From: Craig Messinger
To: Helen Donaldson
Date: 2/23/2015 11:46 AM
Subject: Re: 1210 Brighton Avenue

Thanks for revised plans, I can see where they relocated the fire hydrant and seems to be fine.

2 HYDRANT DETAIL
C4.1 NOT TO SCALE

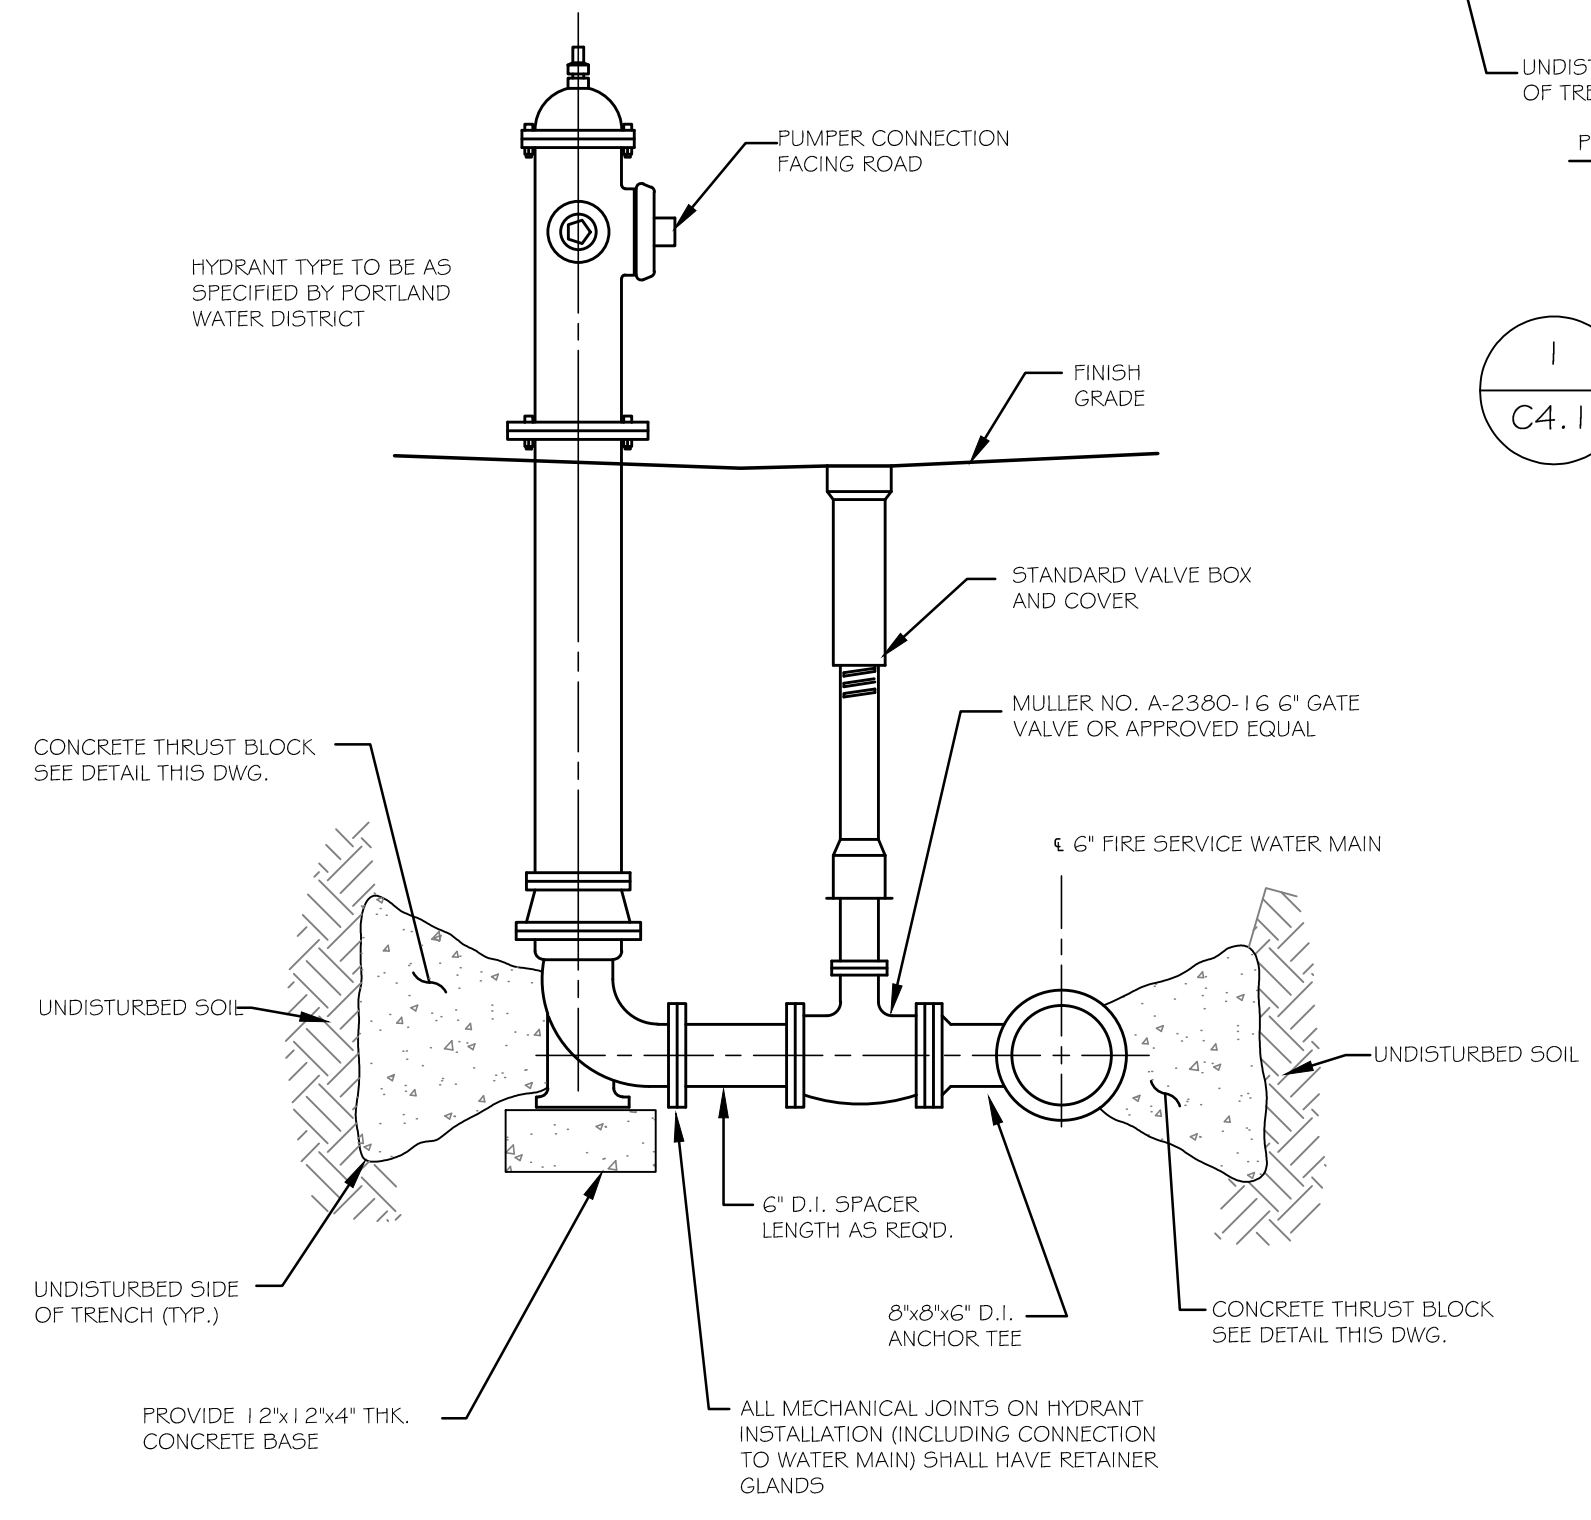
Private hydrants shall be maintained and cleared of snow during the winter months.

Private hydrants shall be painted as follows: Bonnet-gray, caps-silver, Barrel-red.
